**WELWYN HATFIELD BOROUGH COUNCIL
ASSISTANT DIRECTOR (PLANNING)**

DELEGATED APPLICATION

Application No: 6/2019/1101/FULL
Location: Ocado Ltd Gypsy Moth Avenue Hatfield AL10 9BD
Proposal: Erection of an ancillary staff shop following demolition of an existing cabin building
Officer:

Recommendation: Granted

PROPOSED ELEVATIONS

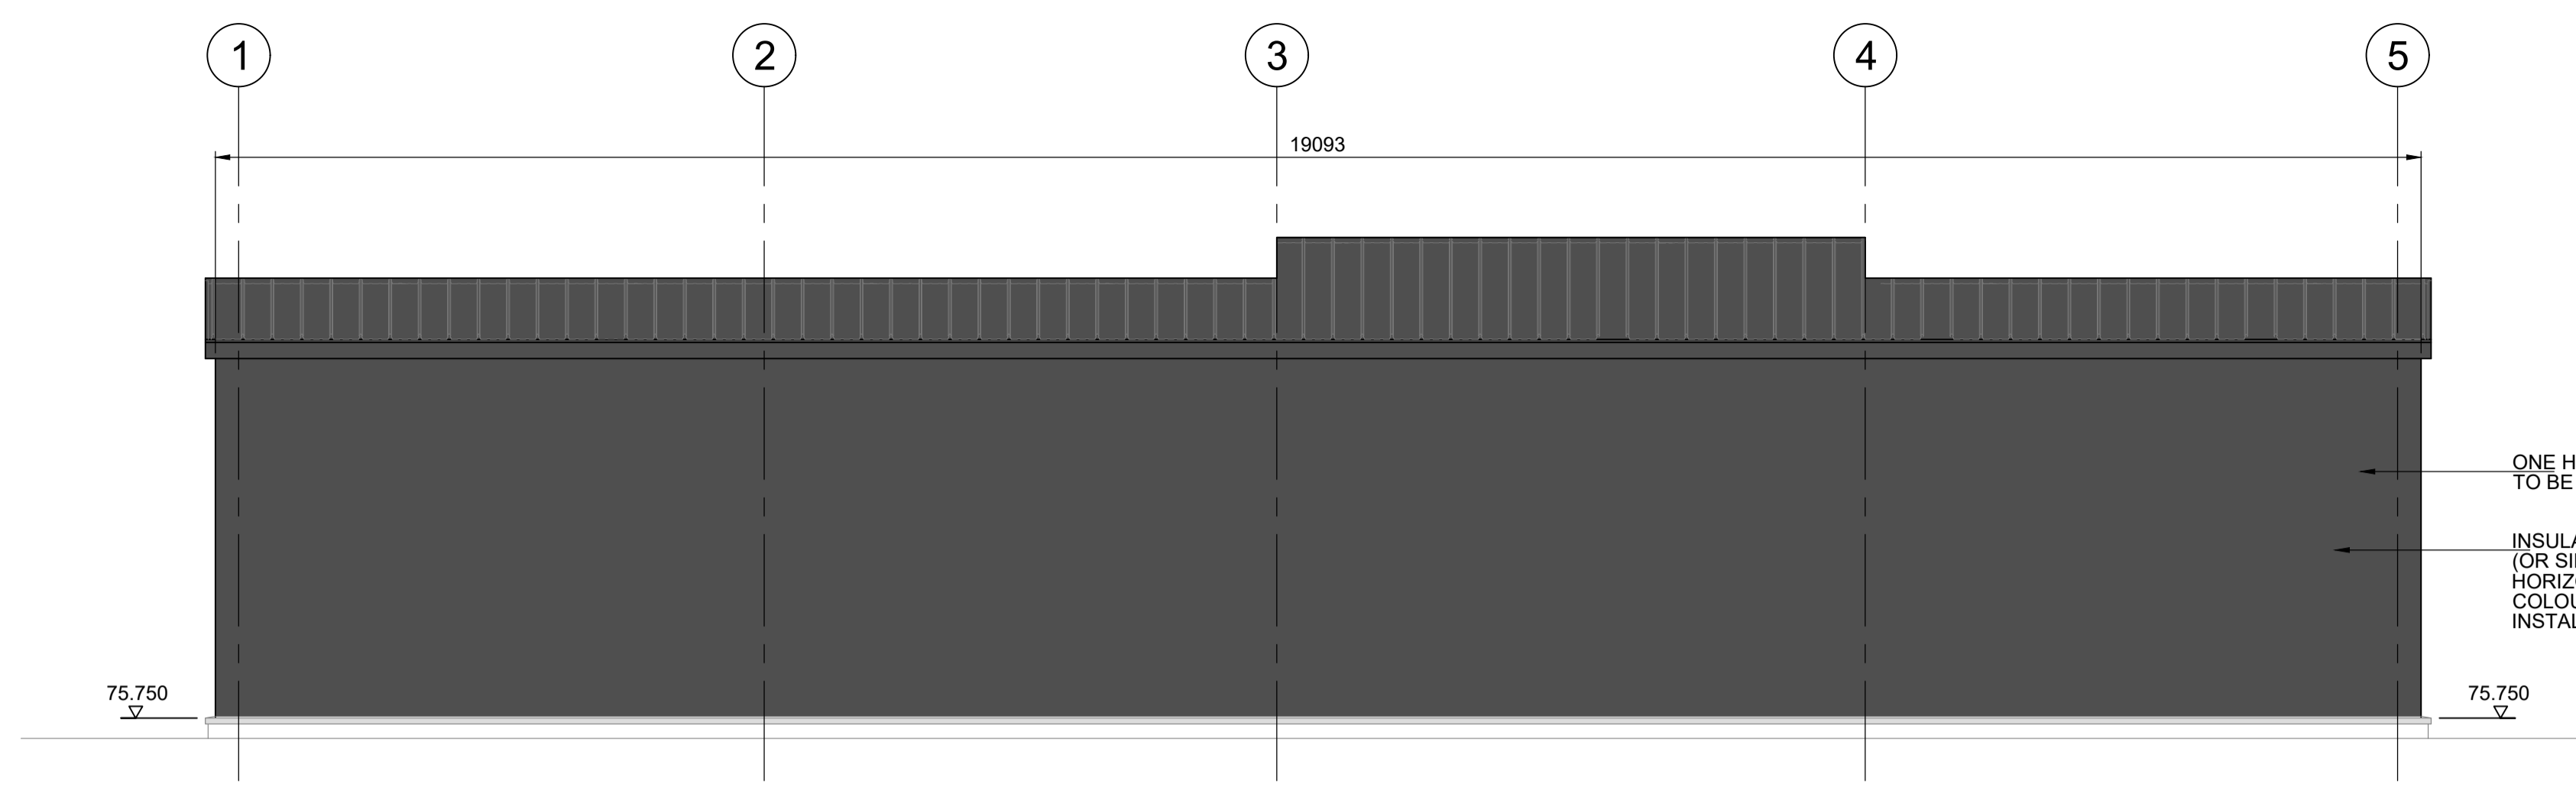
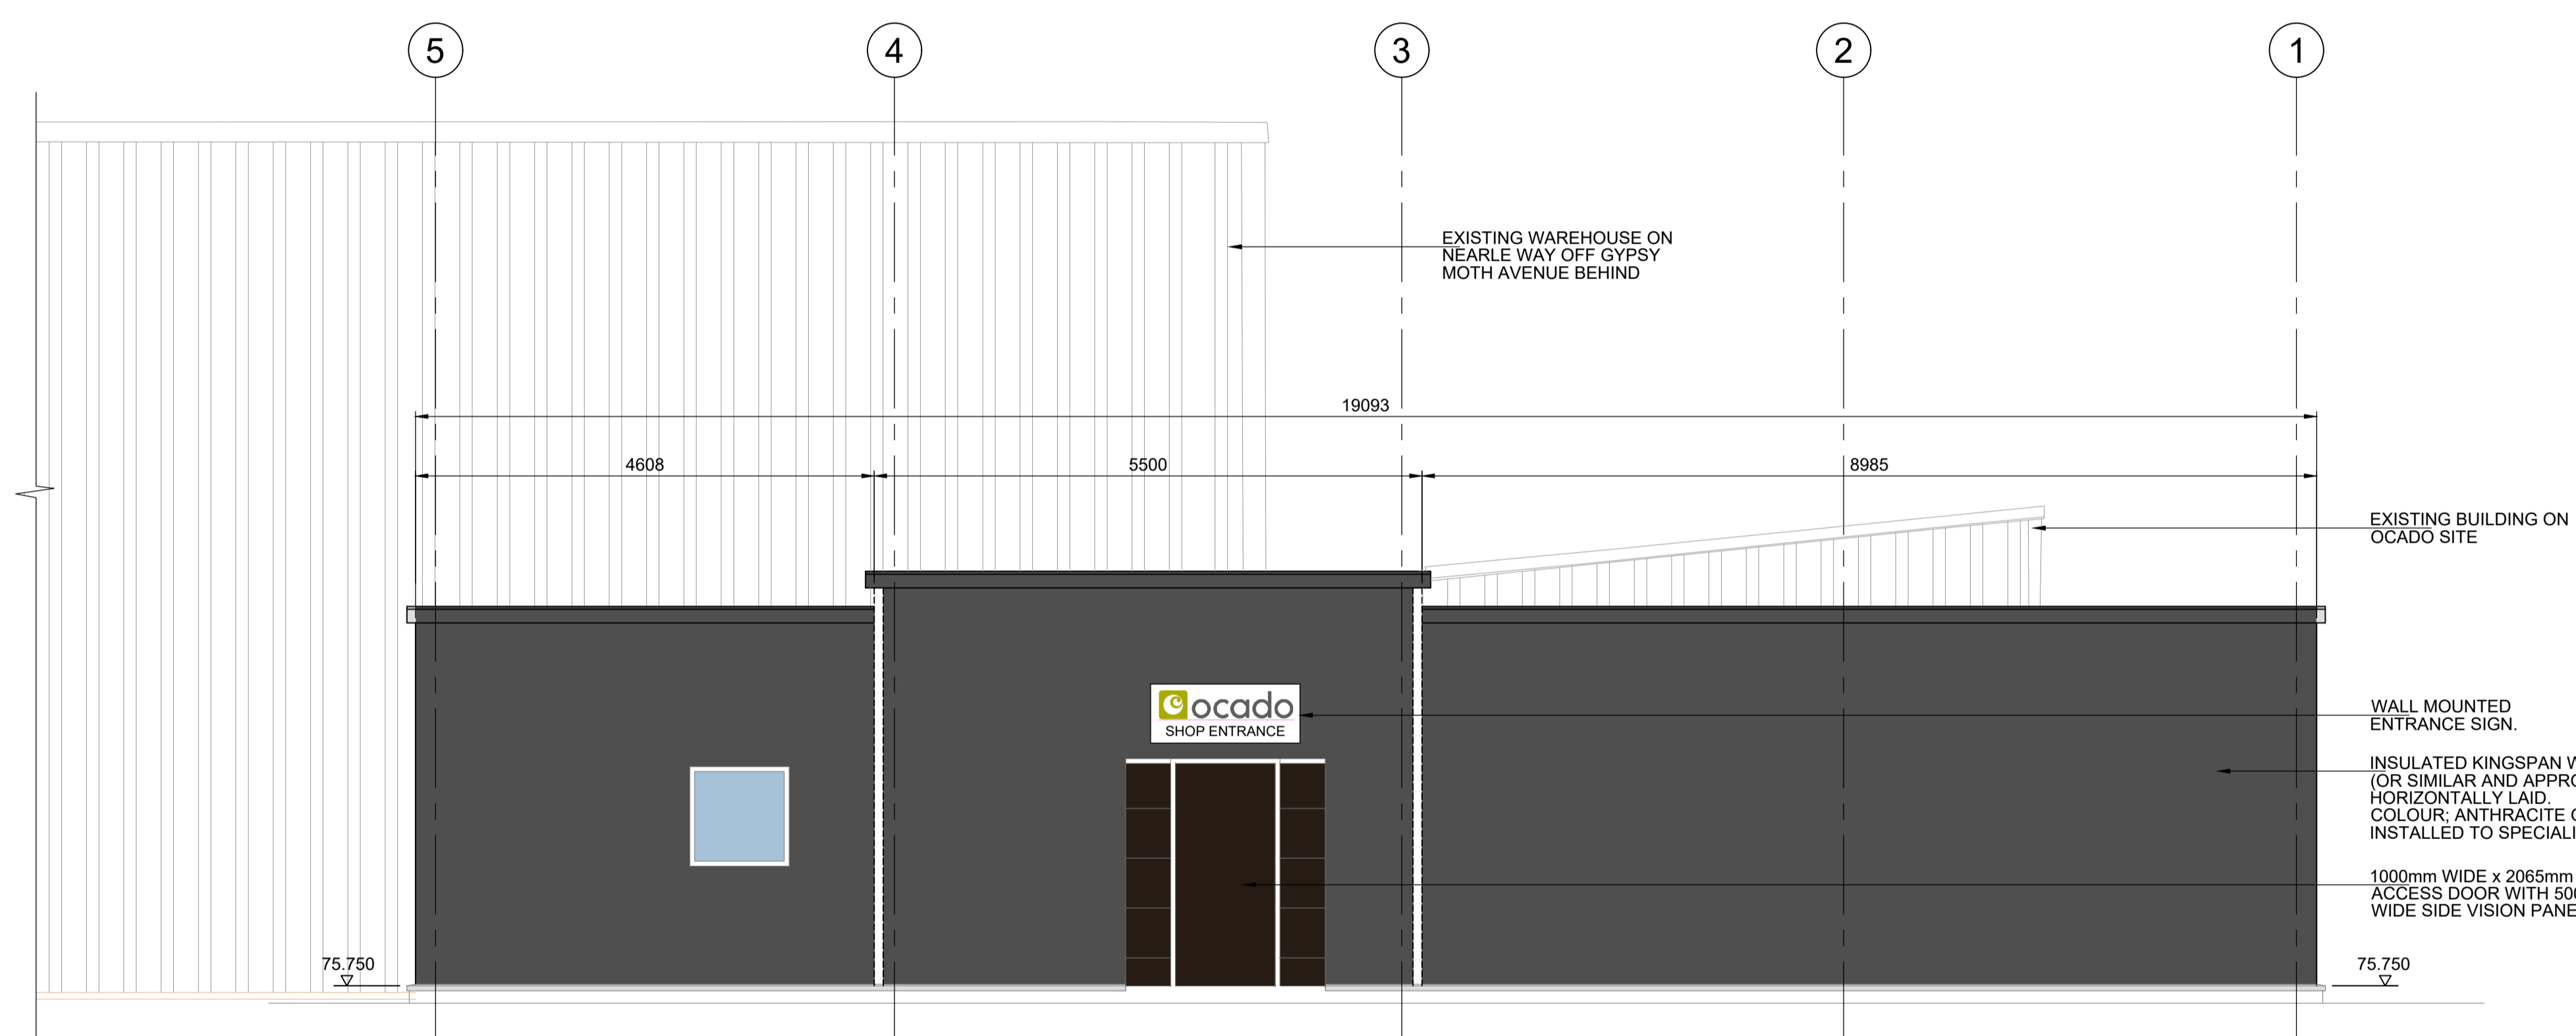
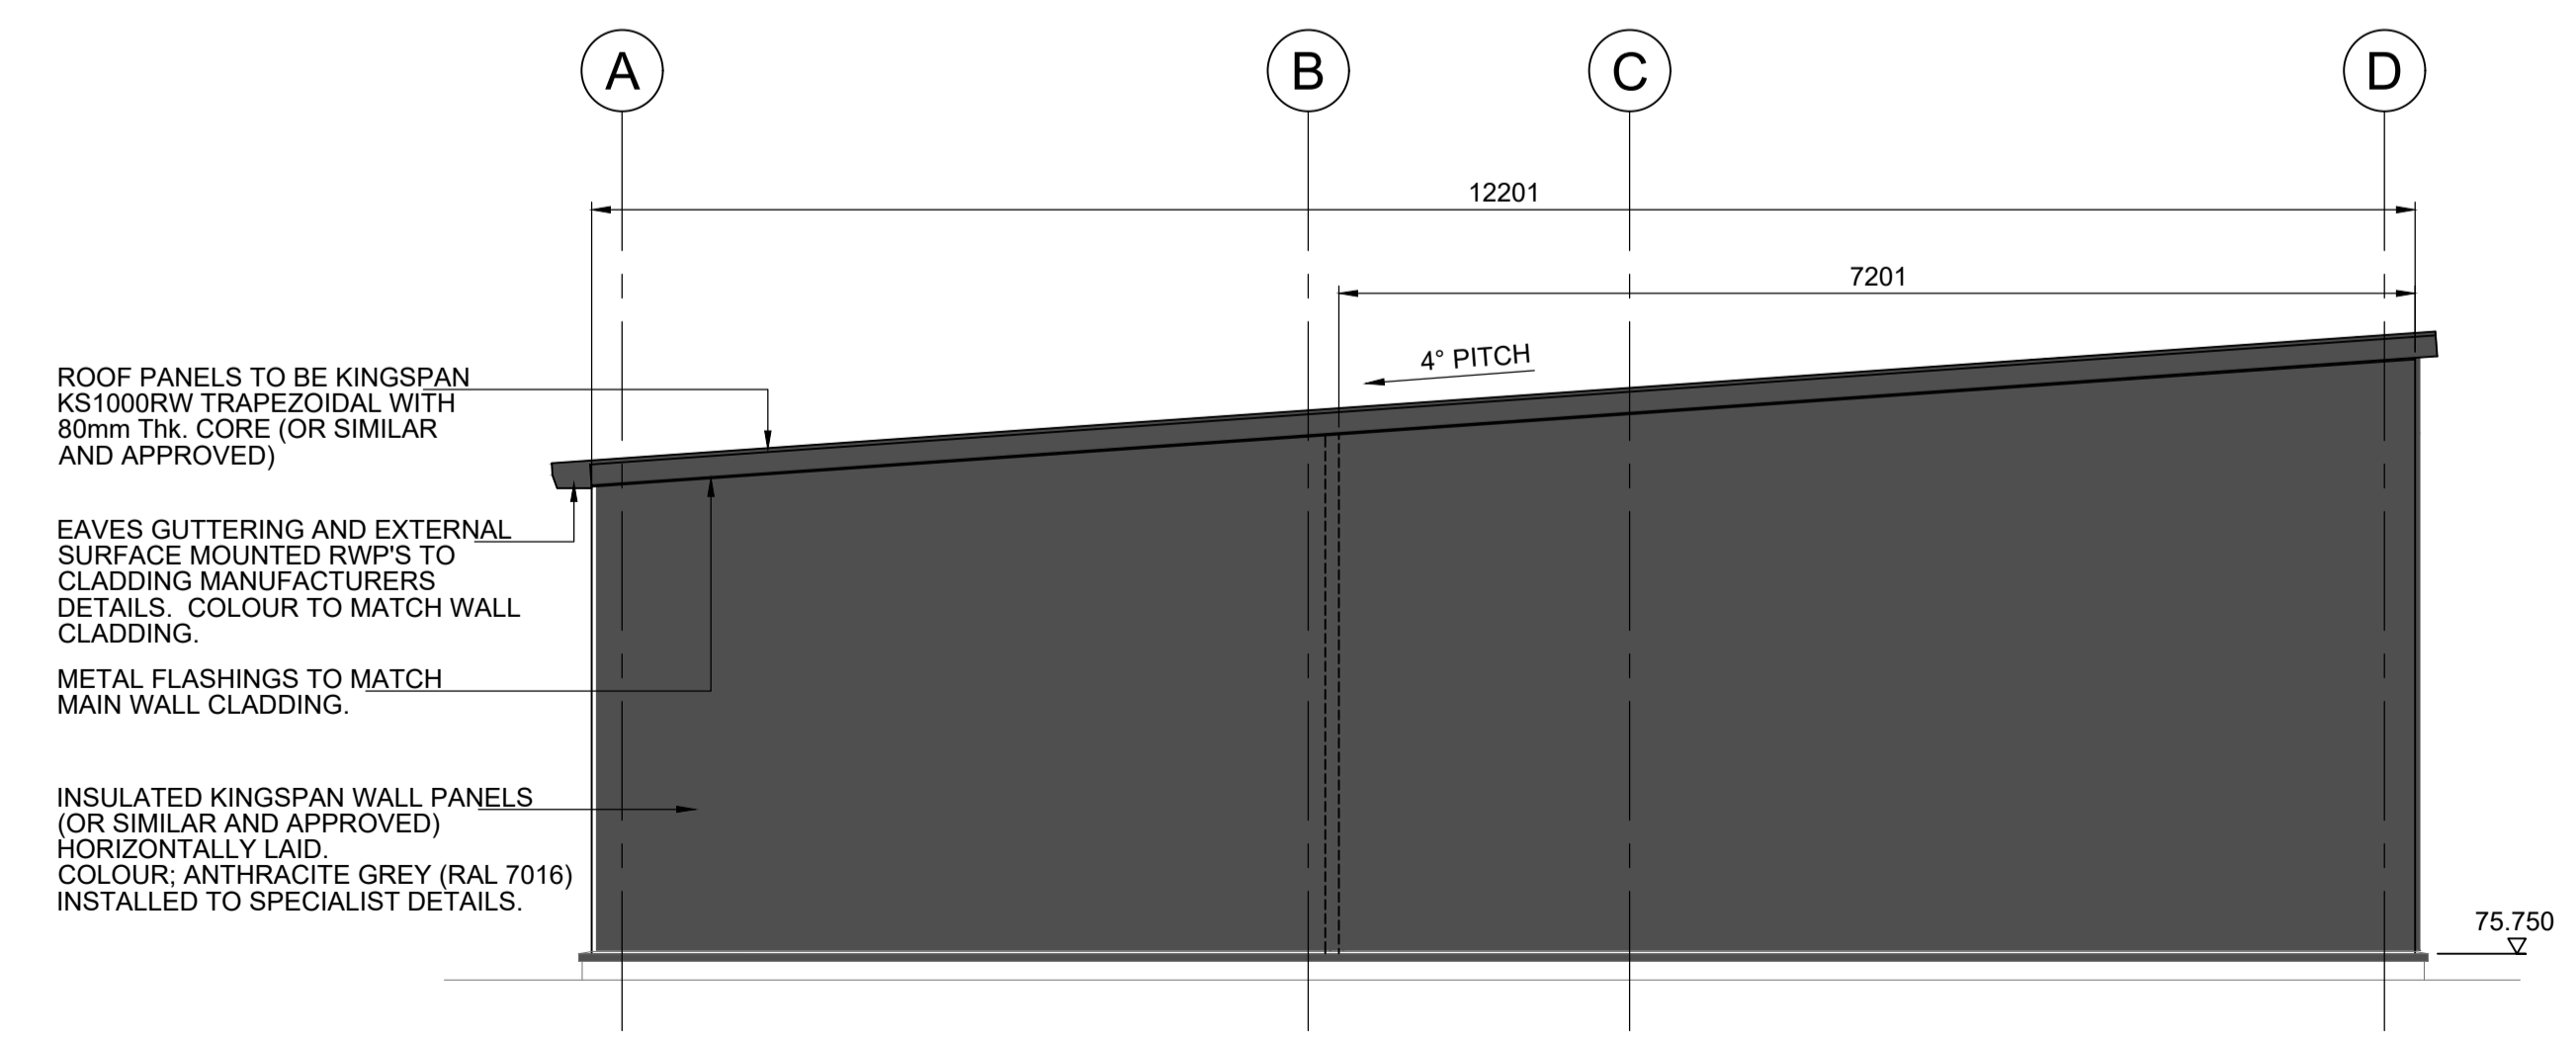
Comment (if applicable): The proposed building is mainly rectangle in shape and has a small projection to the north that is proposed to be used as a shop entrance. The unit would measure approximately 154 sqm located on an area of hard surface. It would have a mono-pitched roof measuring 4.15 metres at its top. The proposed development would be clad with anthracite grey kingspan wall and roof panels.

While it is acknowledged that the proposed building has a footprint wider than the existing cabin, it is overall considered that the siting and scale of the proposed unit would not appear intrusive or out of keeping within the context of the Business Park. Furthermore, the design and materials are considered to be reflective of the character and appearance of the site.
